Ribble Valley Borough Council  
Housing & Development Control

Your ref: 3/2022/0974  
Our ref: D3.2022.0974  
Date: 22<sup>nd</sup> November 2022

Application no: **3/2022/0974**

Proposal: **Proposed demolition of 126 Ribchester Road and erection of replacement dormer bungalow with detached garage.**

Proposed Site Plan - 1:500

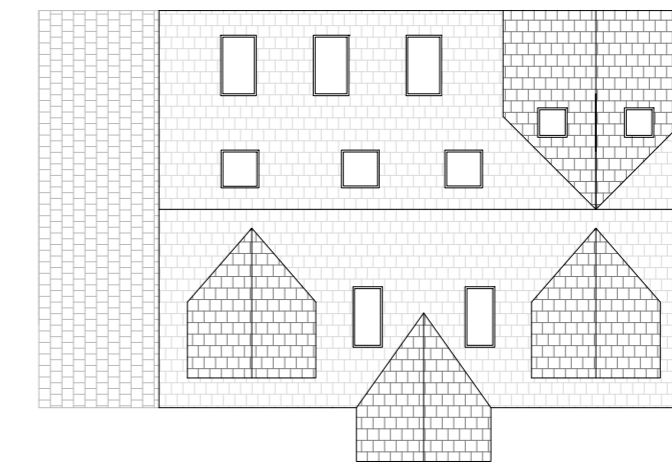
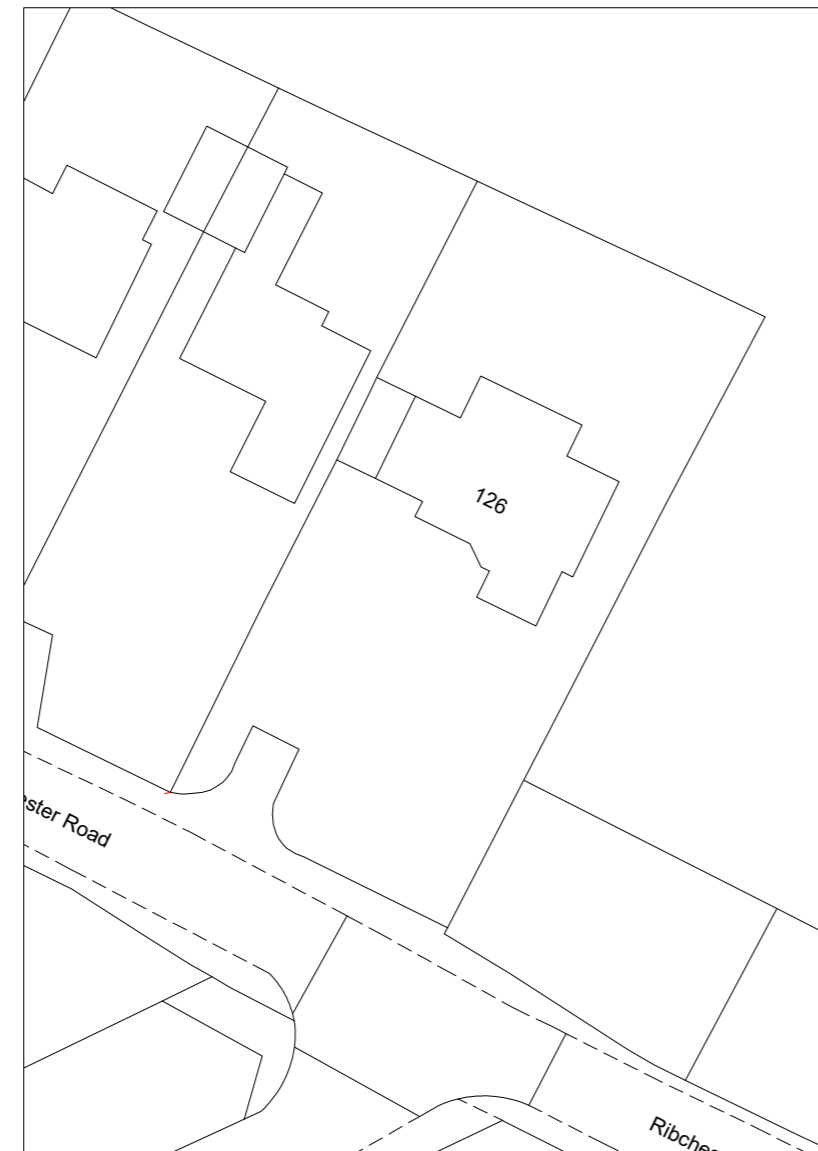
The LHA have reviewed GHA drawing number Hin.1068.3224.03 titled " Proposed Plans & Elevations. Proposed & Existing Site Plan. Location Plan" and the other supporting documents and are aware that the site will provide a car port, a detached double garage and a driveway which will be used as the parking arrangements for the 3-bed dwelling. This complies with the LHAs parking guidance as defined in the Joint Lancashire Structure Plan which requires a 3-bed dwelling to provide 2 car parking spaces. Therefore, the LHA have no objection to the proposal.

1. The development hereby permitted shall not be occupied until such time as the parking and turning facilities have been implemented in accordance with GHA drawing number Hin.1068.3224.03. Thereafter the onsite parking provision shall be so maintained in perpetuity.
